Kirklees Flood Management & Drainage (Lead Local Flood Authority) – Consultation

Consultation on Application Number: 2018/92216

Address: land off, Netherley Drive, Marsden, Huddersfield, HD7 6HL

Proposal: Erection of 5 dwellings

NETHERLEY DRIVE, MARSDEN
 EXTRACT FROM ENVIRONMENT AGENCY MAPPING (GOV.UK)
 RISK FROM FLOODING FROM RIVERS OR SEA
 EXTRACT TAKEN 03.07.2018 : NTS

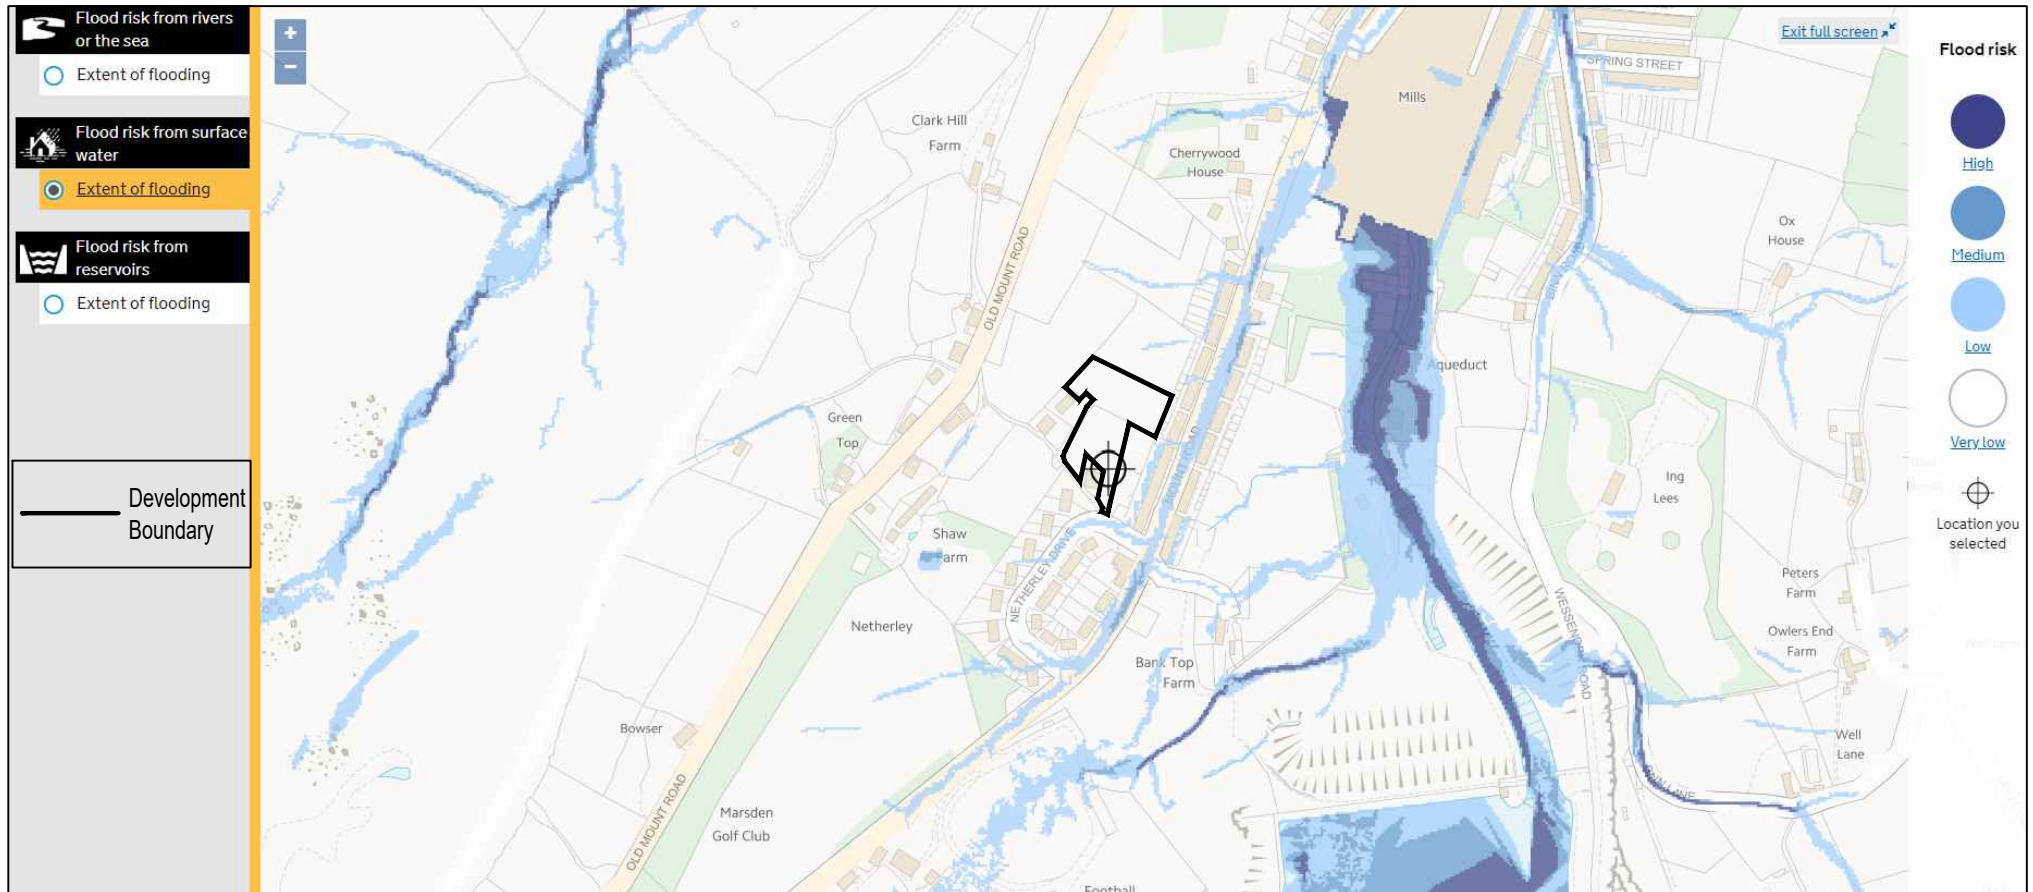
For the wider blue line boundary, surface water flood risk mapping suggests flows from land above and from land within the blue line will flow to the area proposed as mitigation storage. In our experience it is likely that a watercourse (small or otherwise) is located in this area. The same reasoning applies to surface water flow patterns in land to the east.

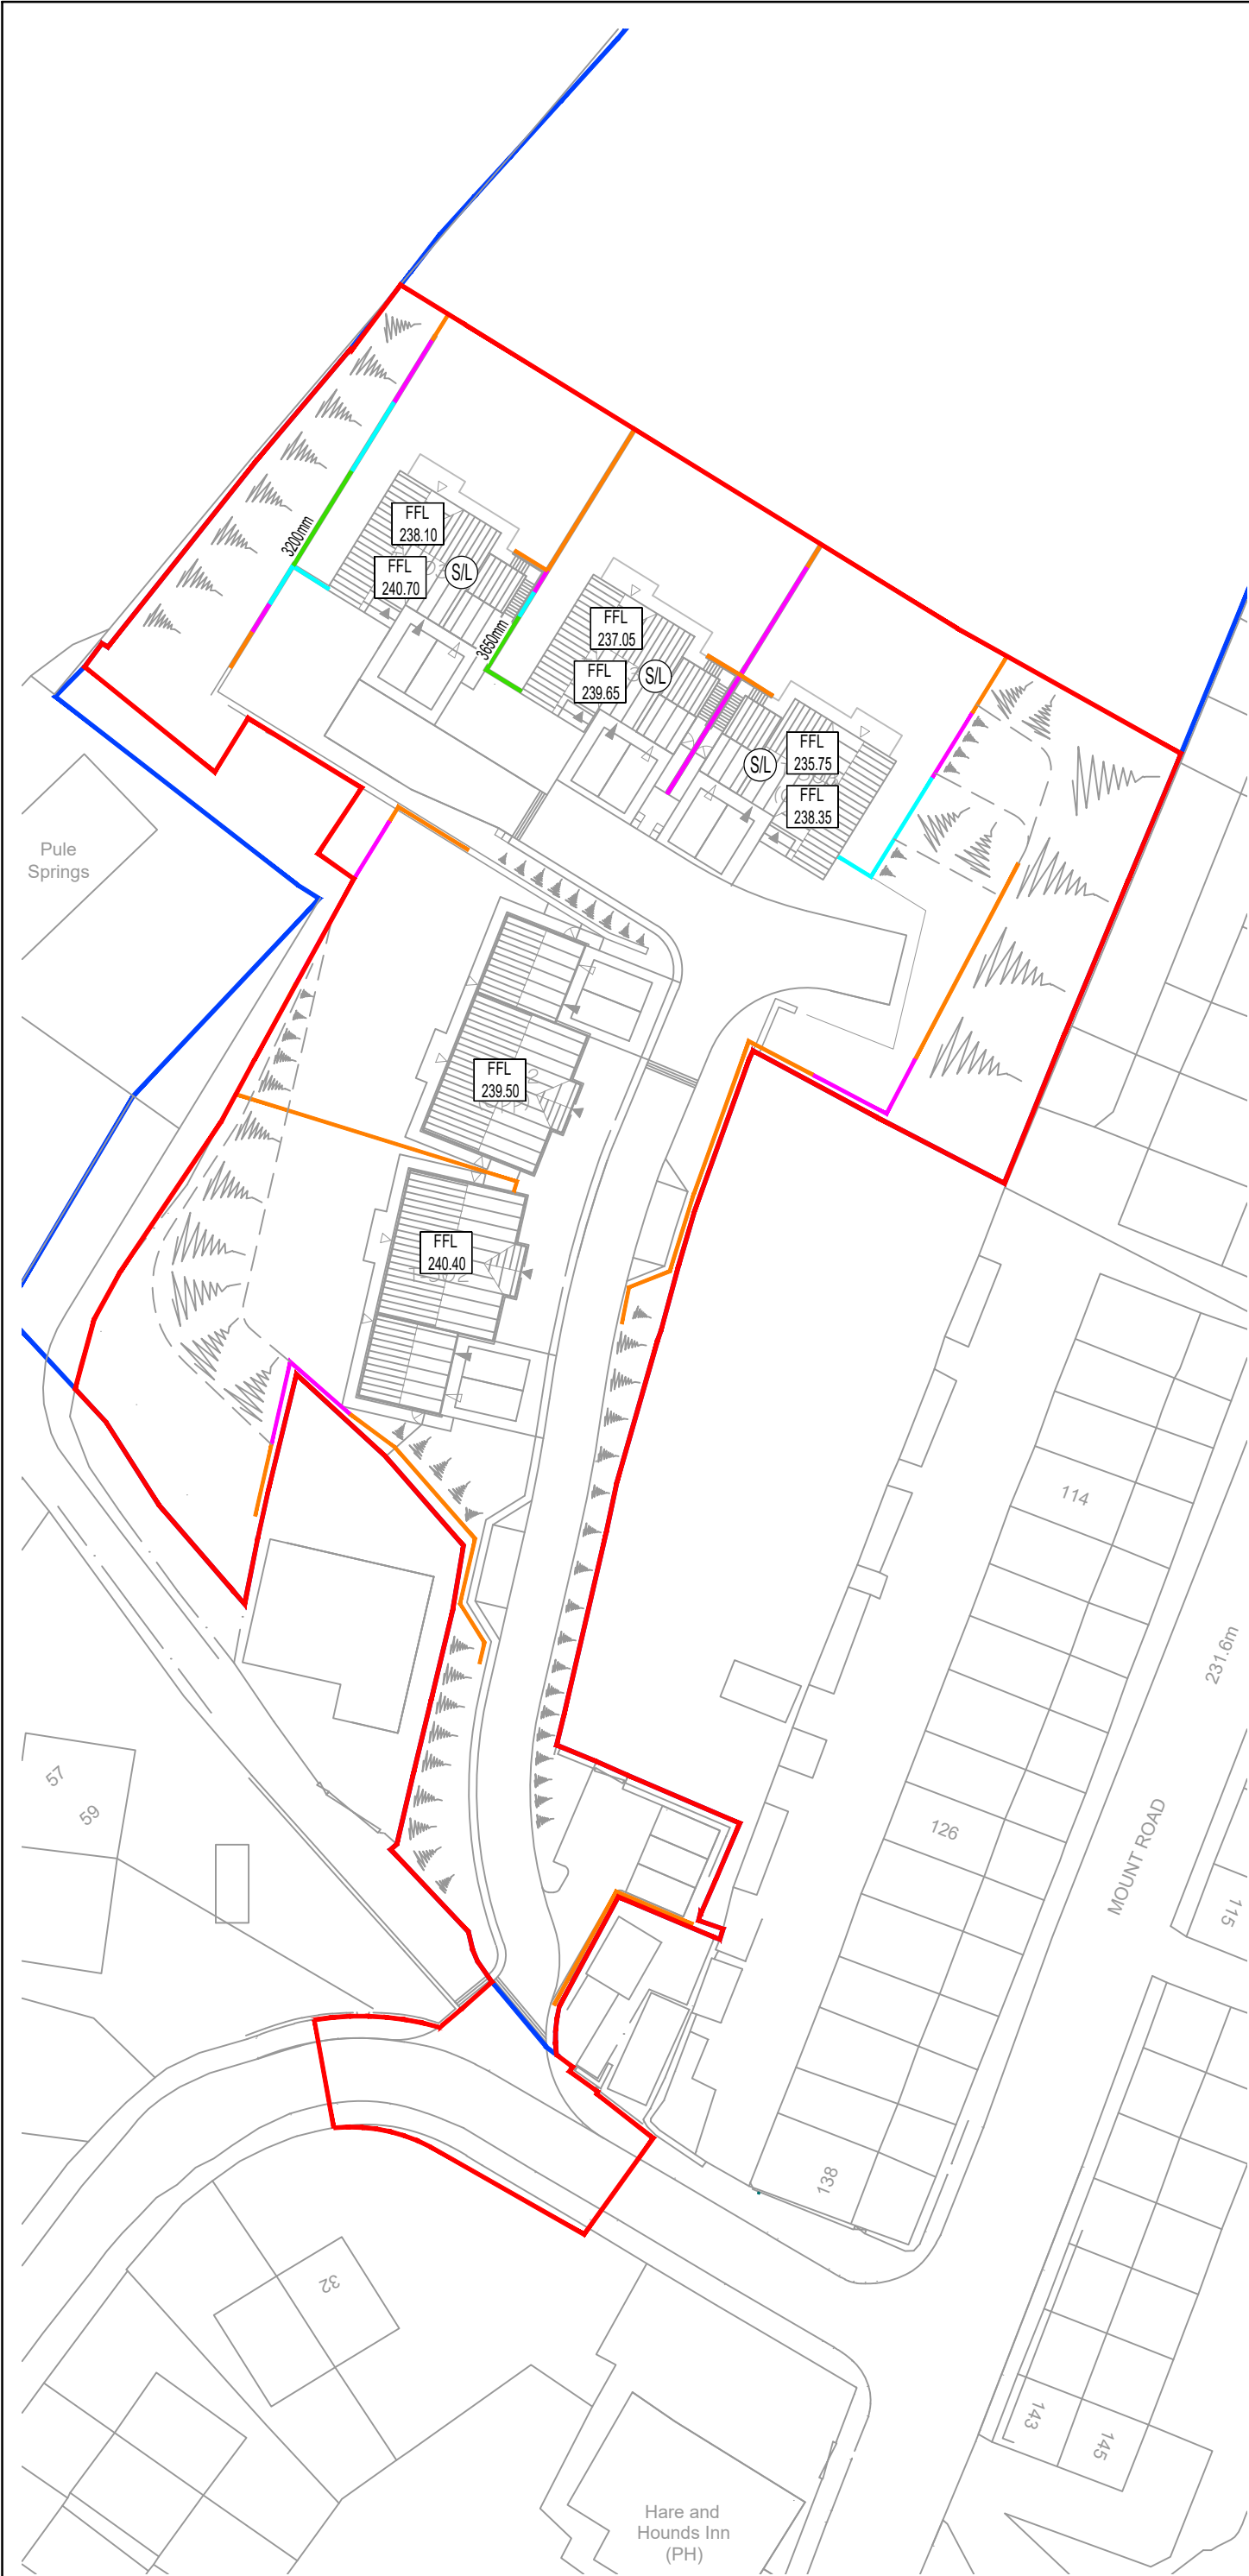
Kirklees Flood Management and Drainage OBJECTS to this application as flood risk is increased and the due to the proposed point of connection for surface water disposal.

- **Surface water disposal must mimic that of the current site. There is no discharge (greenfield or otherwise) currently from this land to the proposed point of connection. We therefore would not sanction this connection as Land Drainage Authority/Lead Local Flood Authority. Greenfield run off calculations stated in the FRA are therefore not relevant to the system described.**
- **The use of a surface water pump station introduces risk not currently present for the surrounding area and existing properties.**

We would object to any solutions that involve pumping land drainage to piped systems that wouldn't ordinarily receive them or be designed to receive them. As water flows downhill this is the case for the stated pipework in Netherley Drive.
